March 2, 2022

Re: M-51 Industrial Grading – *Technical Review 1*
PA 22002

RE: M-51 Industrial, File# PA22-002
Fill Import For Future Development
Parcel #'s 31052700301100, 31052700300100, 31052700201000 & 31052700200700

EXISTING DRIVEWAY TO BE USED FOR SITE ACCESS UNTIL WSDOE APPROVAL FOR WORK WITHIN THE 51ST AVE. NE R/W

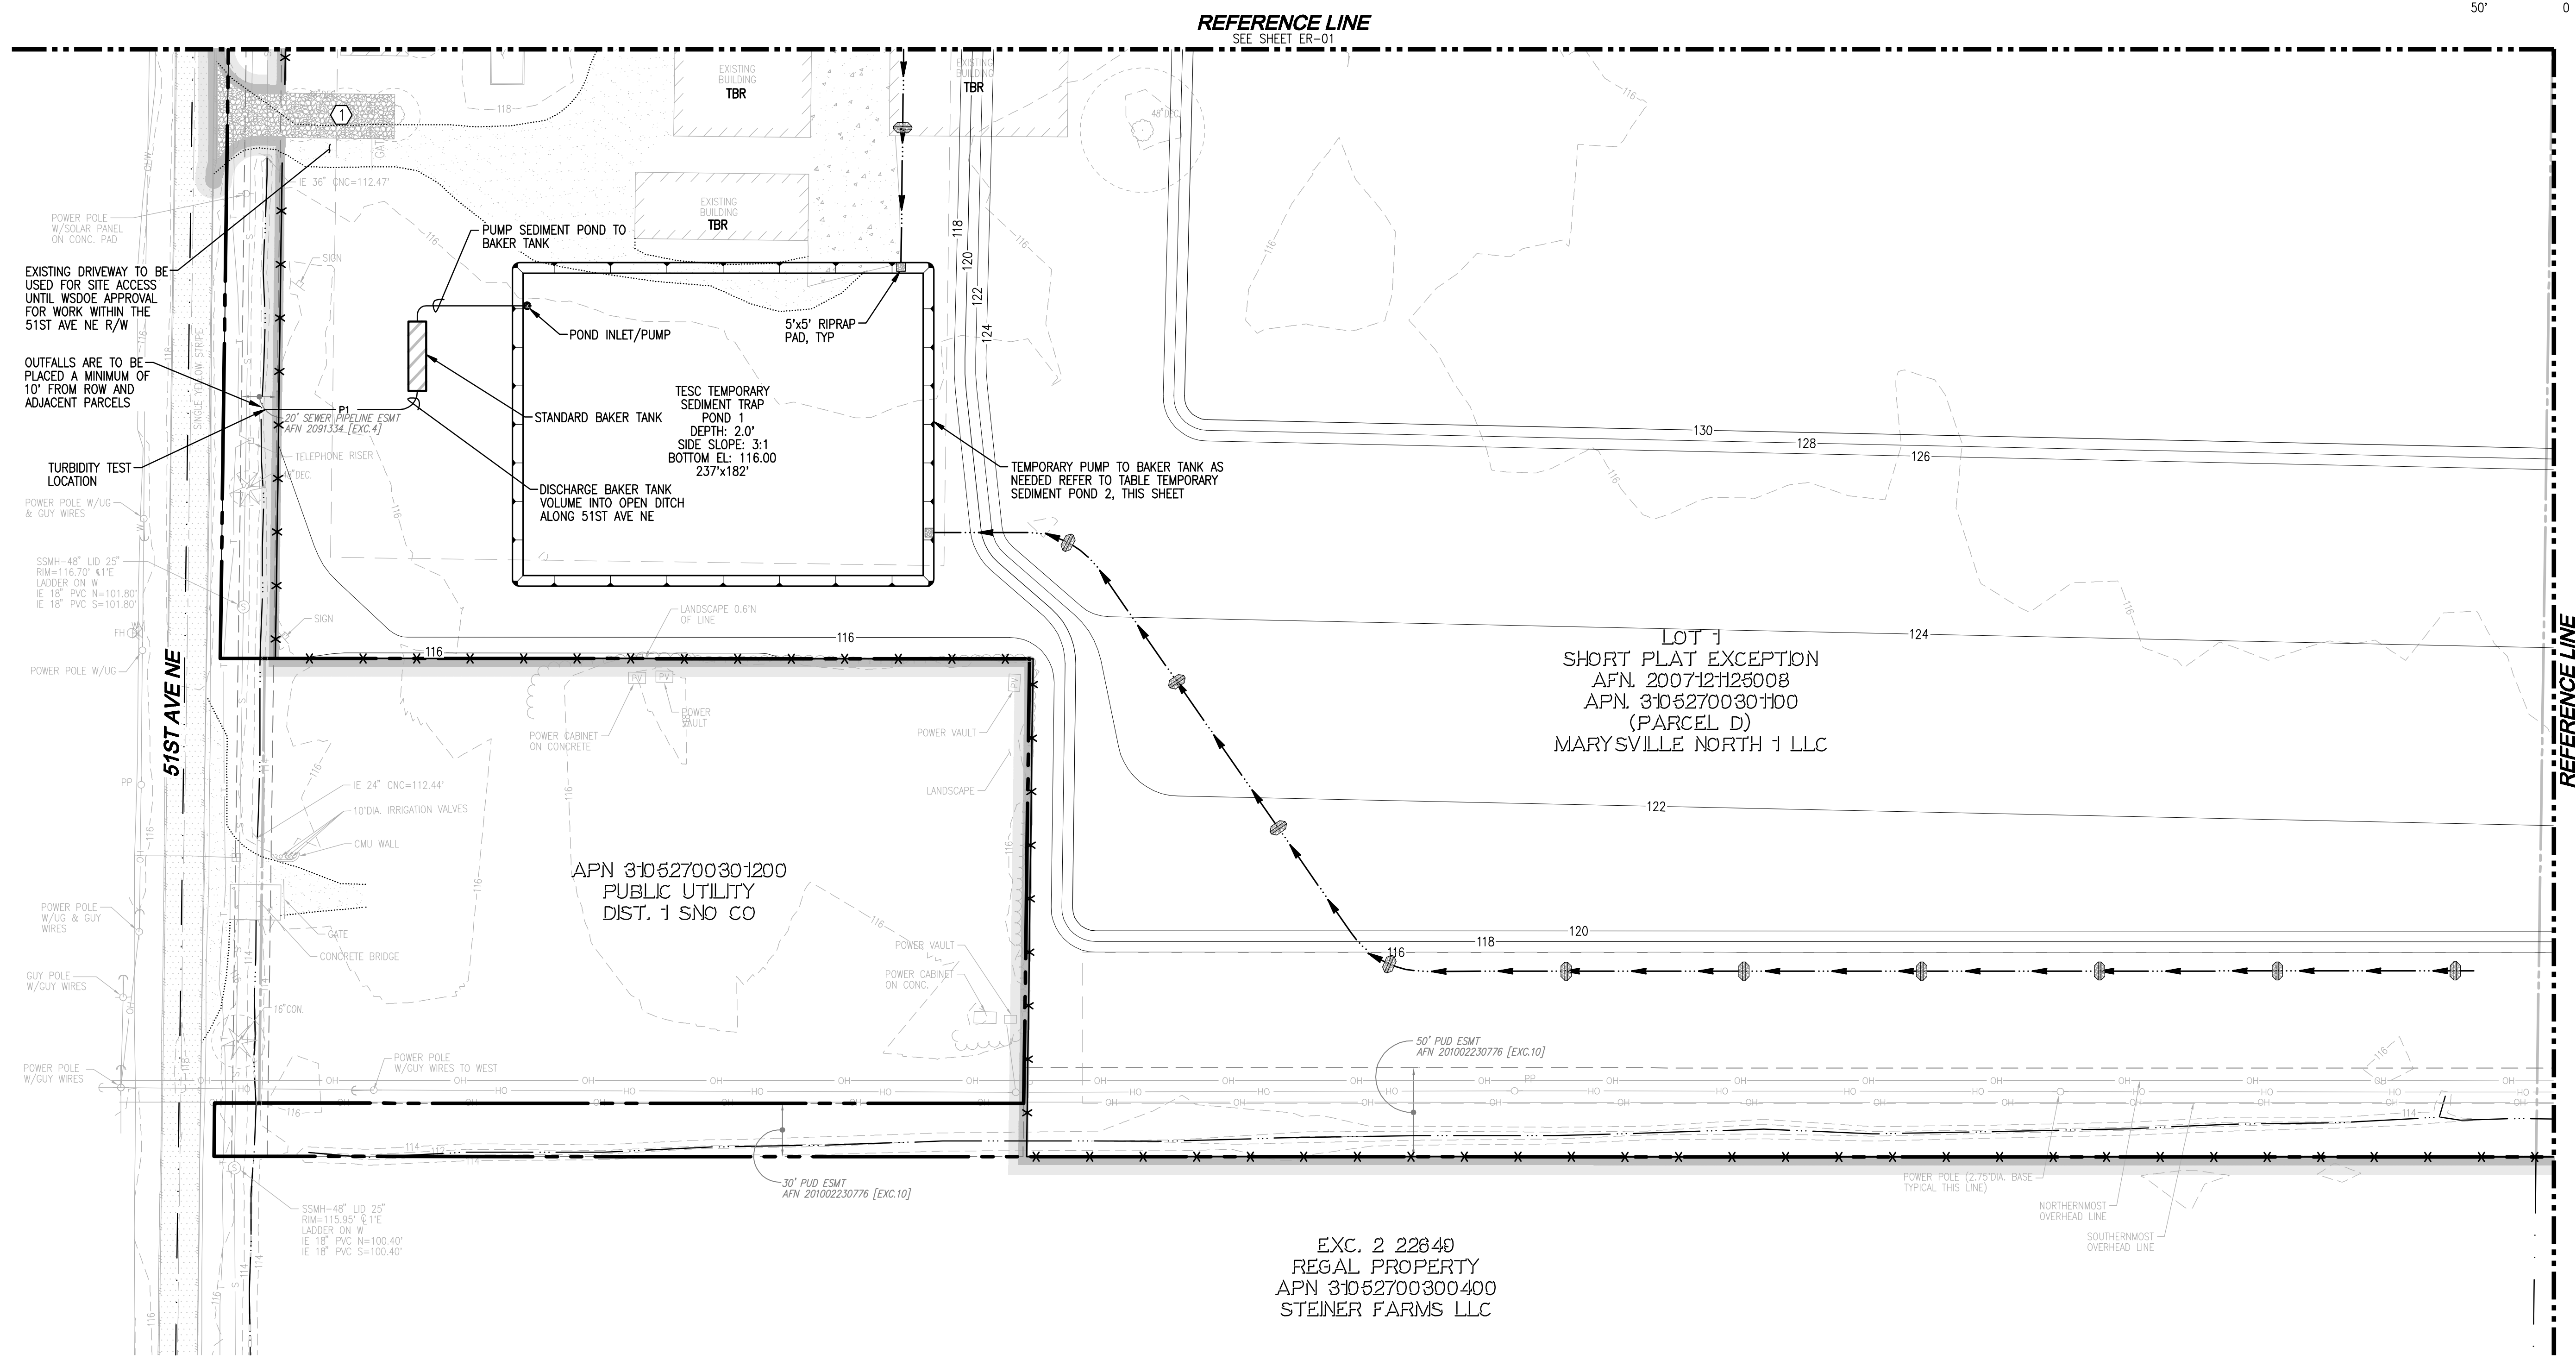
5. The grading plans shall be revised to avoid any impacts to the off-site wetlands and associated buffers and the 51st Avenue NE linear wetland and associated buffer. This includes piping and installation of the proposed construction entrance from 51st Avenue NE onto APN 31052700200700.

The existing site entrance on APN 31052700301100 can be used for grading activity.

GRADING WITHIN THE LIMITS OF THE 51ST AVE NE DITCH TO BE DONE UPON APPROVAL FROM WSDOE. WORK WITHIN THE DITCH WILL BE RESTRICTED UNTIL SUCH APPROVAL HAS BEEN OBTAINED. SILT FENCE TO BE INSTALLED AROUND PERIMETER OF THE DITCH TO PREVENT SEDIMENT MIGRATION FROM THE CONSTRUCTION SITE.

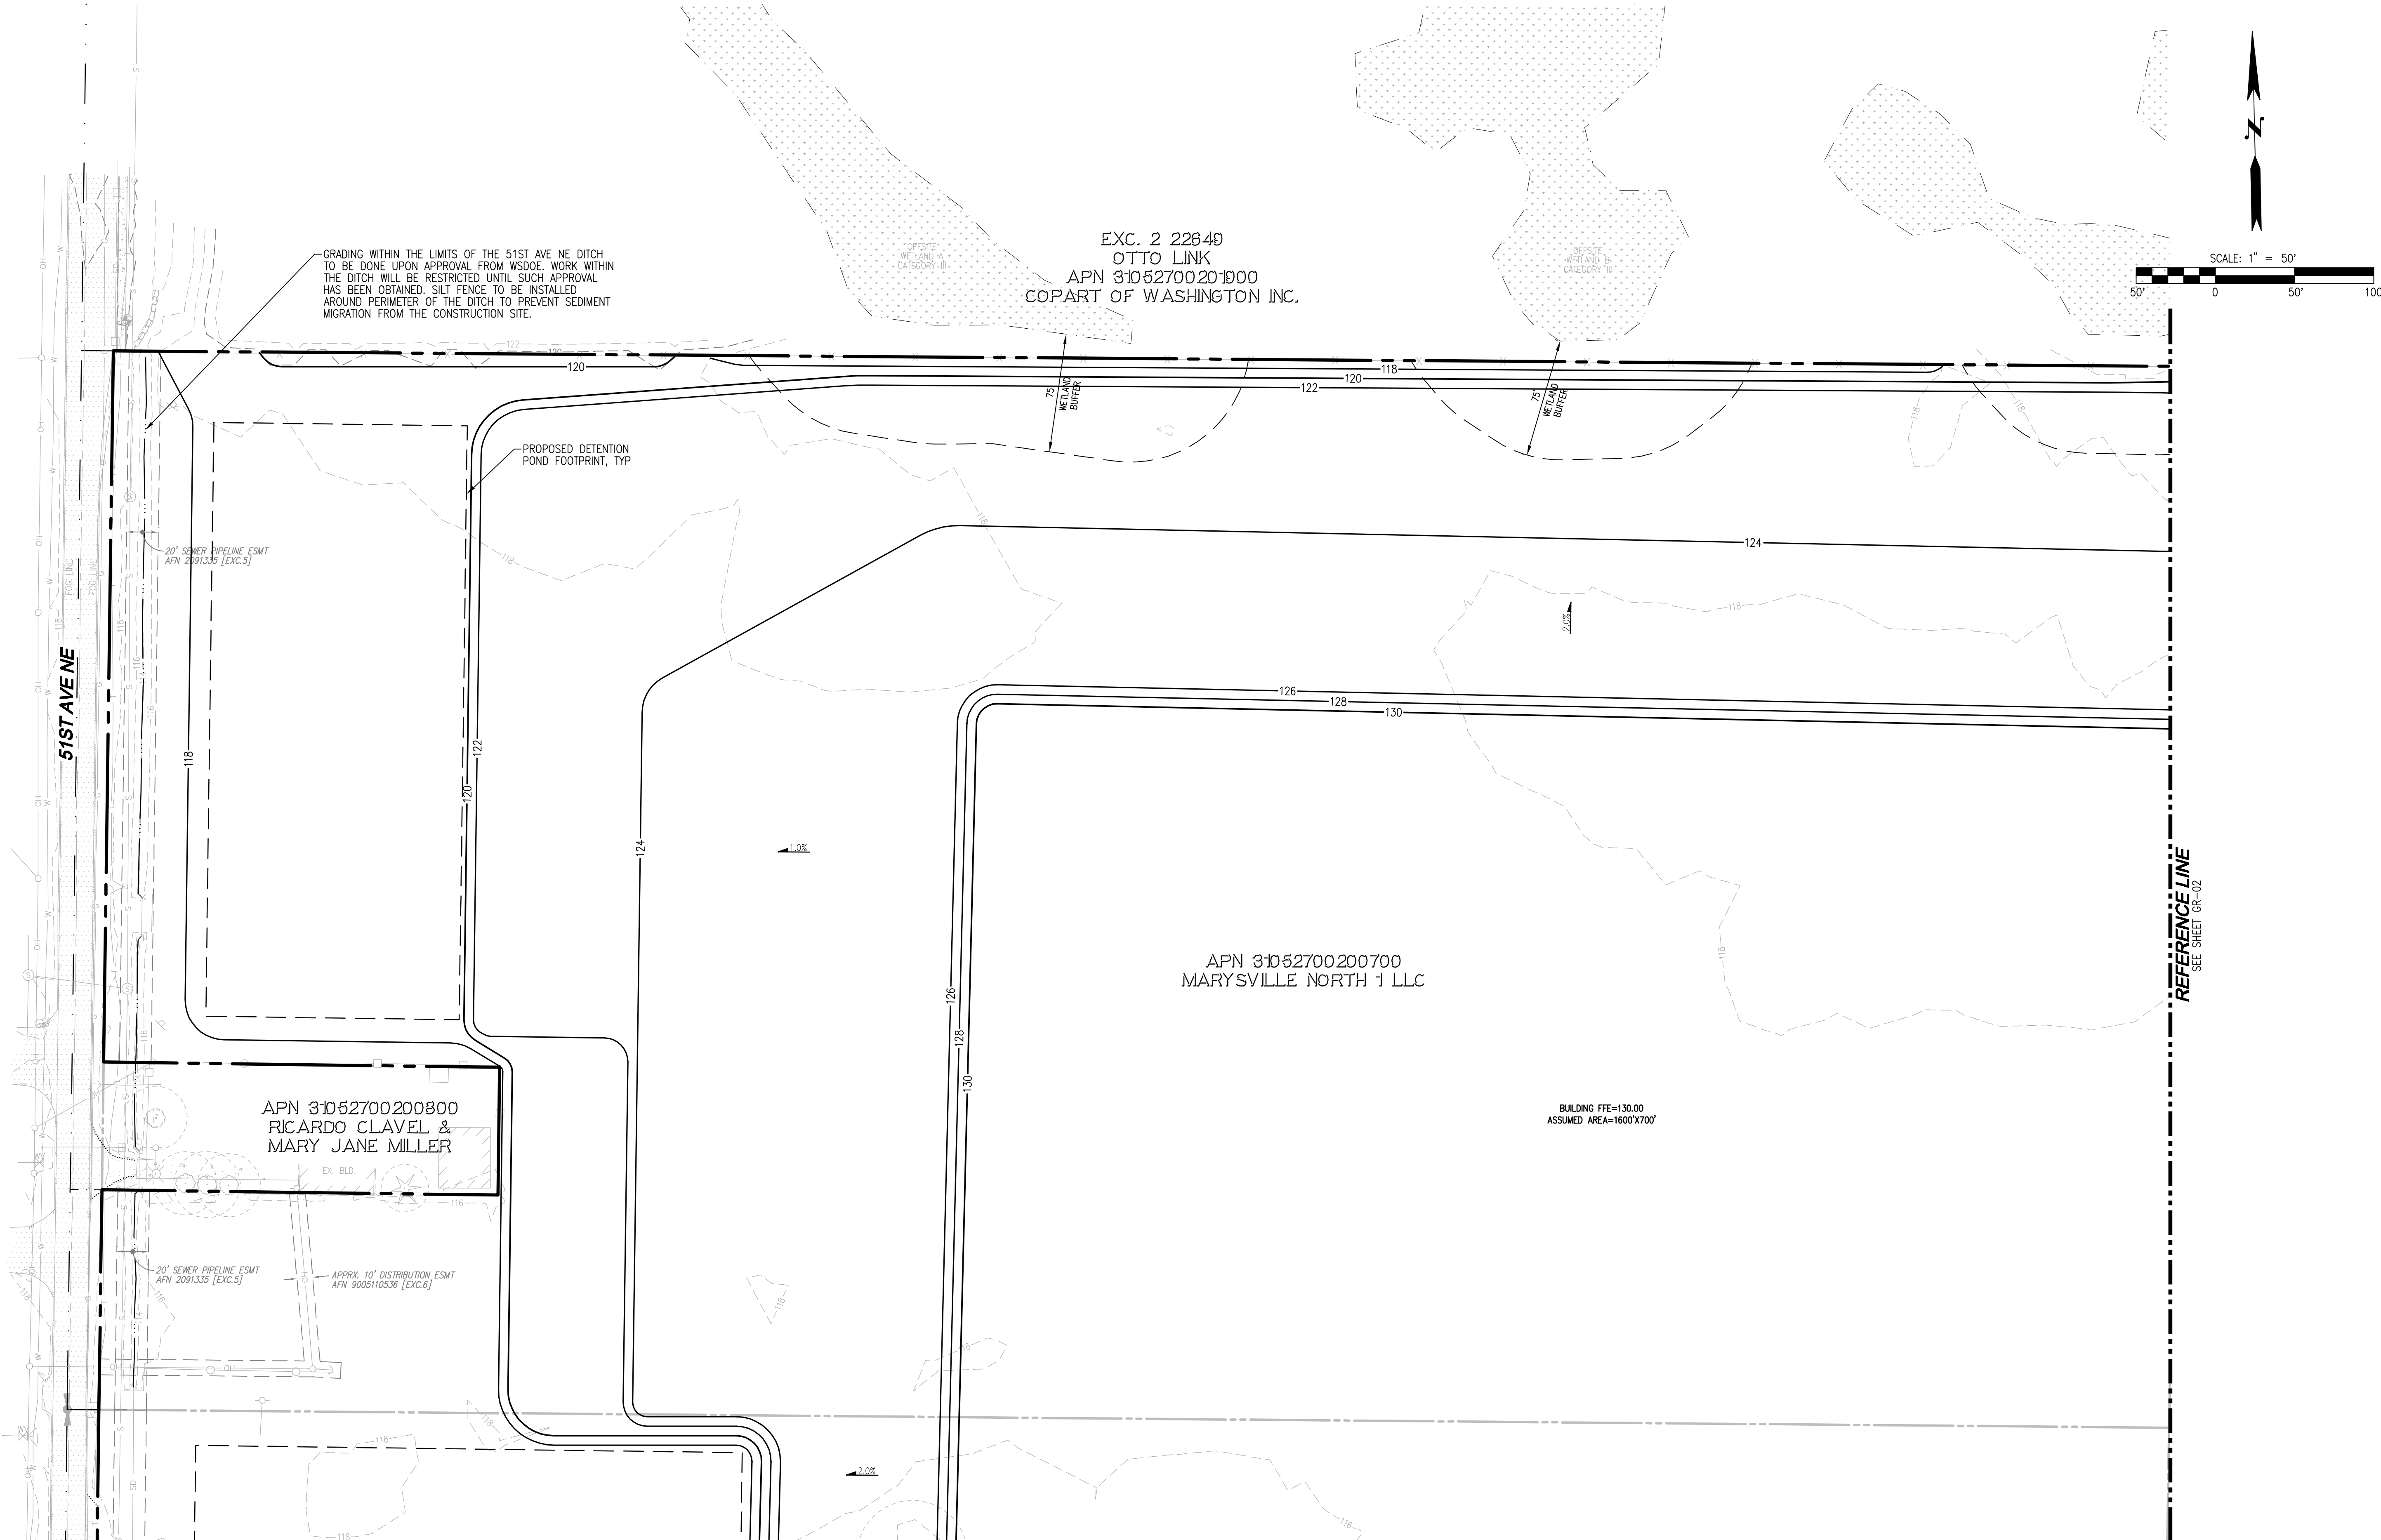
Any temporary, or permanent, impacts to the 51st Avenue NE linear wetland and associated buffer shall be avoided, until the applicant obtains approval from The Corps and DOE to fill the wetland.
